Agency Submissions

Item	Issue	Response
Department of Planning and Environment		
1	Traffic and parking Provide a copy of the Parking Demand Study and Traffic Assessment (October 2017) referenced in the Traffic Impact Assessment.	The parking study and TIA for the carpark (Oct 2017) is provided at Appendix C .
2	Correct inconsistencies in the number of parking spaces to be removed / provided in the proposed development as set out in the Environmental Impact Statement (366 spaces to be removed and 205 spaces to be provided) and Traffic Impact Assessment (447 spaces to be removed and 201 spaces to be provided).	We confirm the numerics in the EIS are incorrect and the proposal will remove 447 spaces and will introduce 201 car parking spaces as stated in the Traffic Report. It is noted that under separate applications a multi-storey car park and several at-grade car parks are being delivered across the Hospital campus that will increase car park provision (refer to Section 2.2 of the ESI). Inclusive of these non-SSD works, the Hospital will increase parking provision by 834 spaces (Refer to Section 7.3 of the Traffic Report at Appendix H of the EIS).

1 PLAN - PROPOSED ROADWORK - MAIN ENTRY
1 : 1000

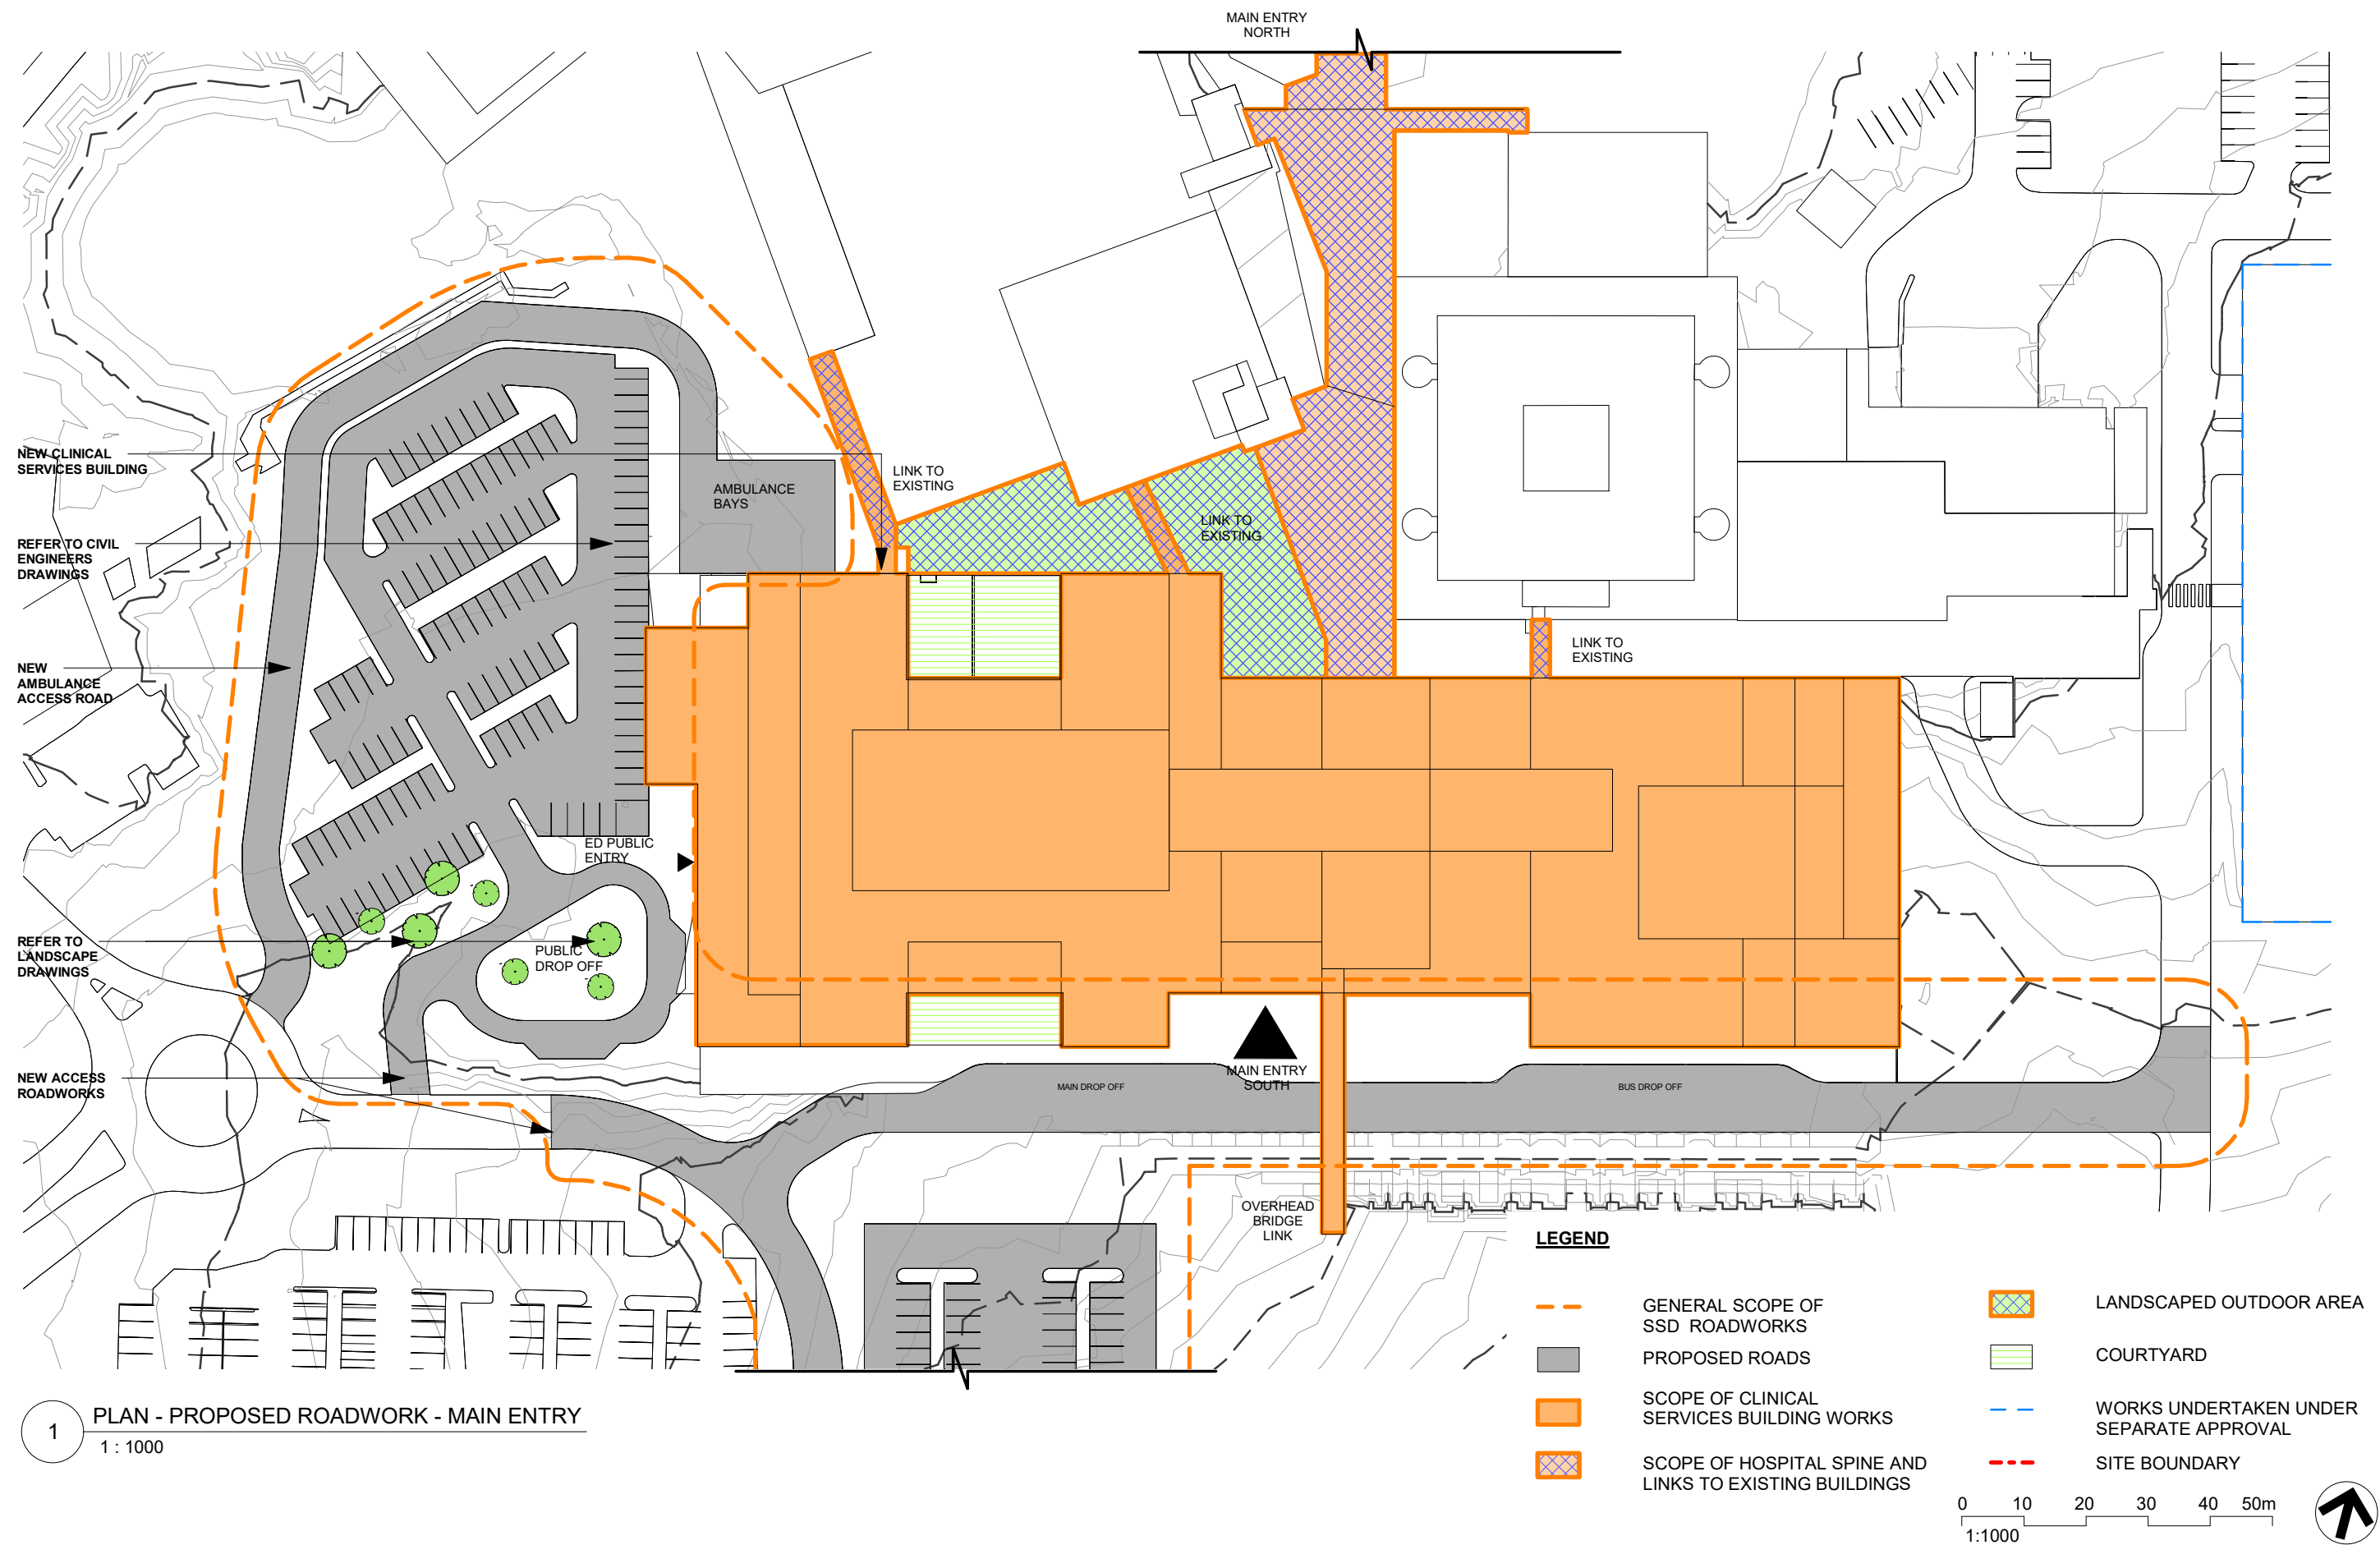
12	<p>Details of the proposed site access, <u>internal vehicular circulation patterns</u> and the parking provisions associated with the proposed development including compliance with the requirements of the relevant Australian Standards (ie: turn paths, sight distance requirements, aisle widths, etc).</p>	<p>As outlined at Section 9 of the Traffic Report the Access and Car Park Assessment states the project is designed to comply with the relevant Australian Standards.</p> <p>Attached is a plan showing the internal vehicular circulation patterns (Appendix D).</p>
13	<p>Details of <u>light and heavy vehicle movements</u> (including vehicle type and likely arrival and departure times). Details of service vehicle movements (including vehicle type and likely arrival and departure times).</p>	<p>It is confirmed that there is no change to the loading, delivery and servicing arrangement for the Hospital by the SSD. The Hospital will continue to utilise the existing loading dock for deliveries and waste collection.</p> <p>Construction vehicles will access the Hospital via the Therry Road roundabout and Appin Road access. A preliminary swept path analyses have been undertaken, demonstrating the ability of vehicles up to a 19m AV accessing the site via the Therry Road roundabout and vehicles up to an 8.4m MRV accessing the site via the Appin Road access (without impeding on the opposing lane).</p> <p>Details of the light vehicle movement and arrival & departure times of construction vehicles are been outlined in sections 8.3 & 8.4 of the Traffic report.</p>

1 PLAN - PROPOSED ROADWORK - THERRY ROAD
1 : 1000

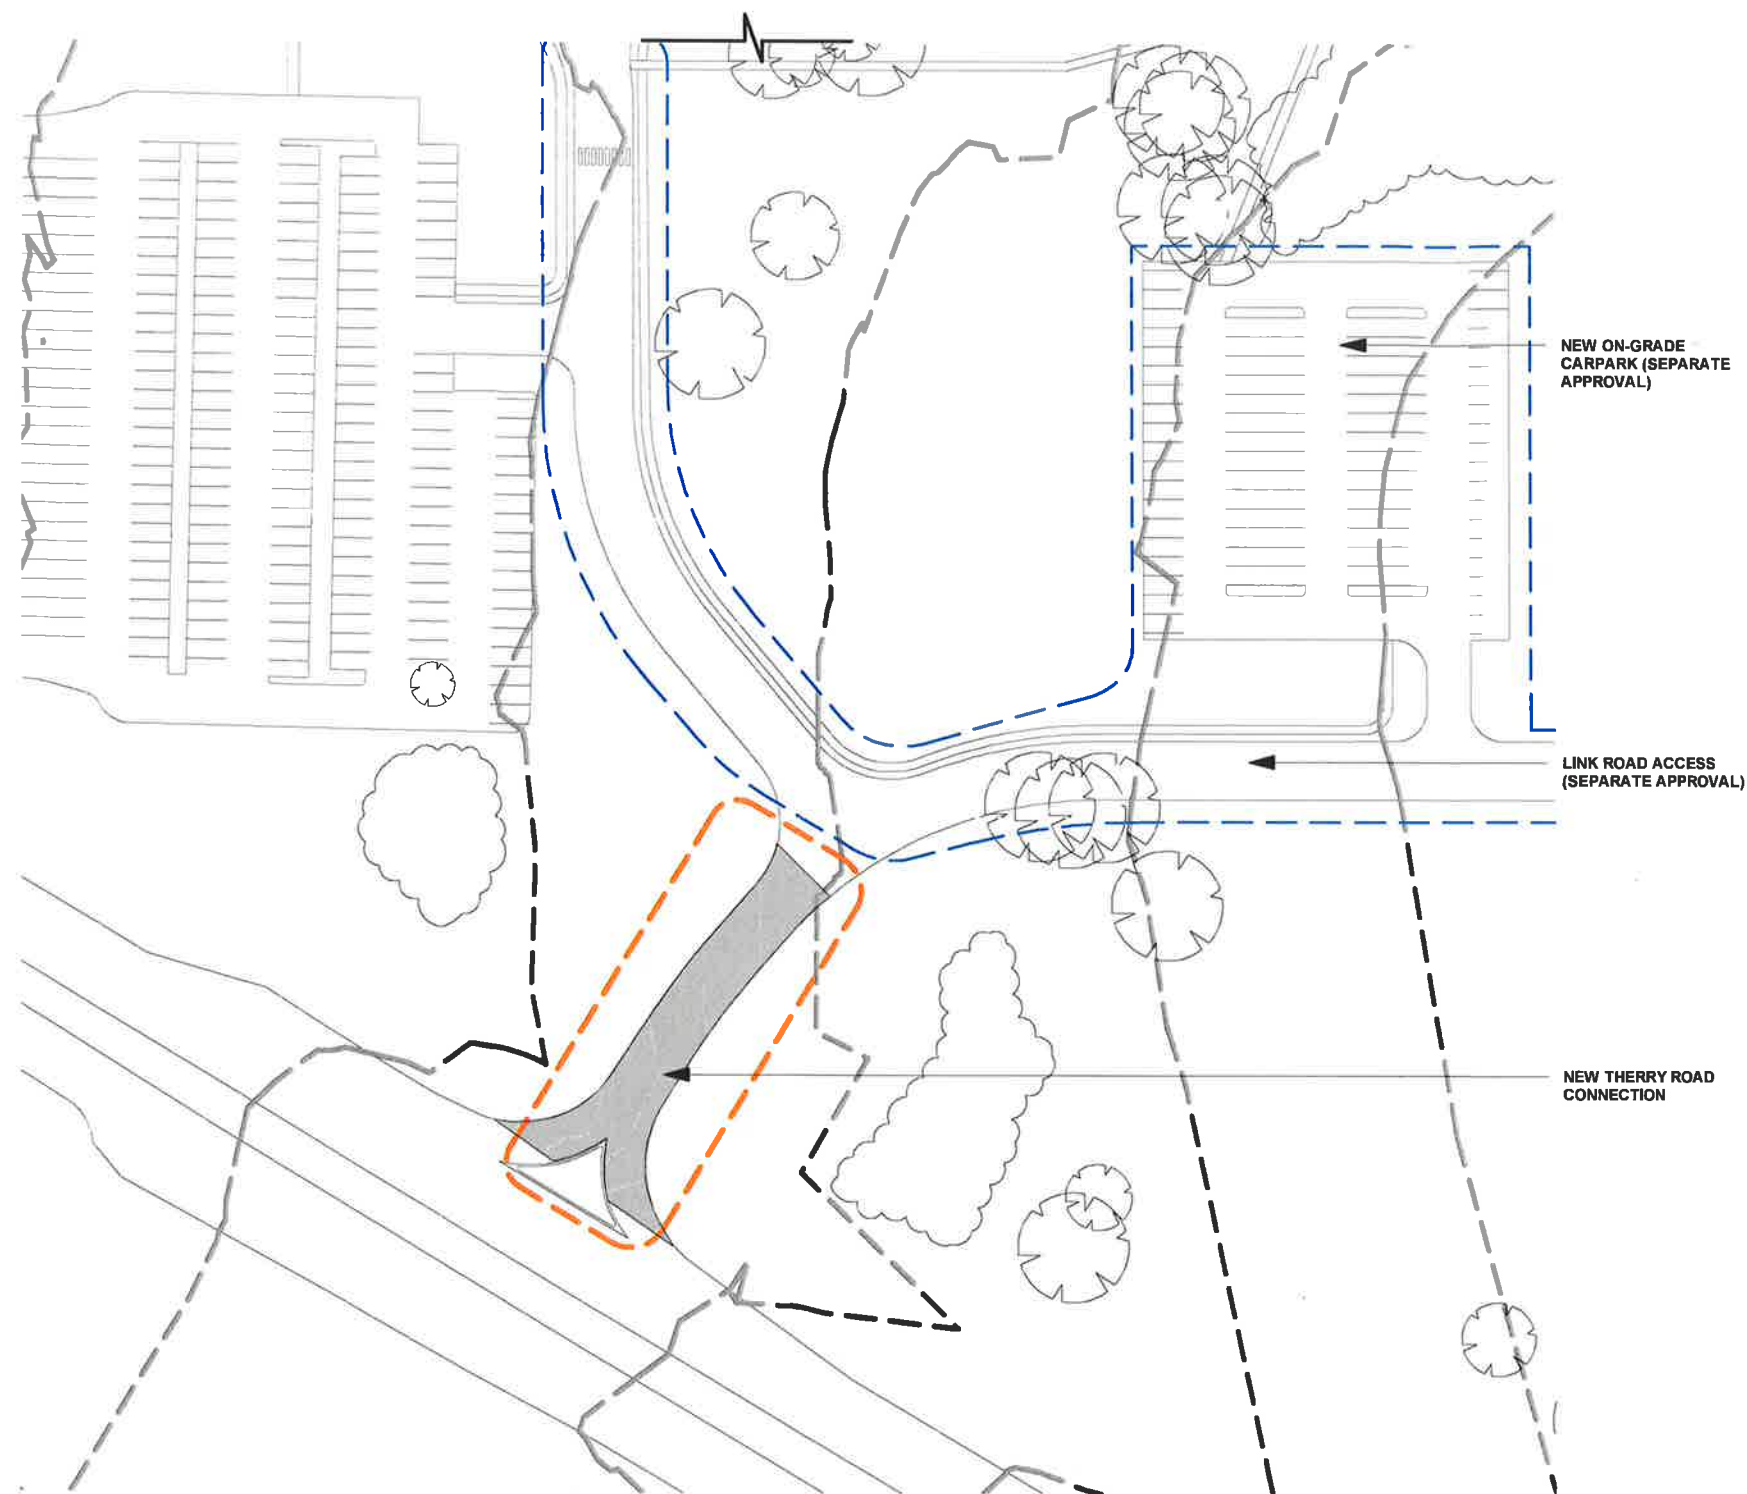
14	<p>The proposed new Therry Street left in/left out intersection is justified on the basis that it will alleviate congestion/traffic volumes at the Therry Street Roundabout, however, in reality all traffic using the new access would need to travel through the Roundabout to access the new access. Only egressing vehicles would be removed from the existing roundabout congestion.</p> <p>In the long term there may be pressure to then seek a right turn for vehicles travelling west into this new access/egress off Therry Street.</p>	<p>The new Therry Road access will be left-in/ left-out and right turn access into Therry Road is not required. As stated in section 8.5.6 of the report, the subject intersection will operate at LOS in both the AM & PM peak with 89% & 74% spare capacity.</p>
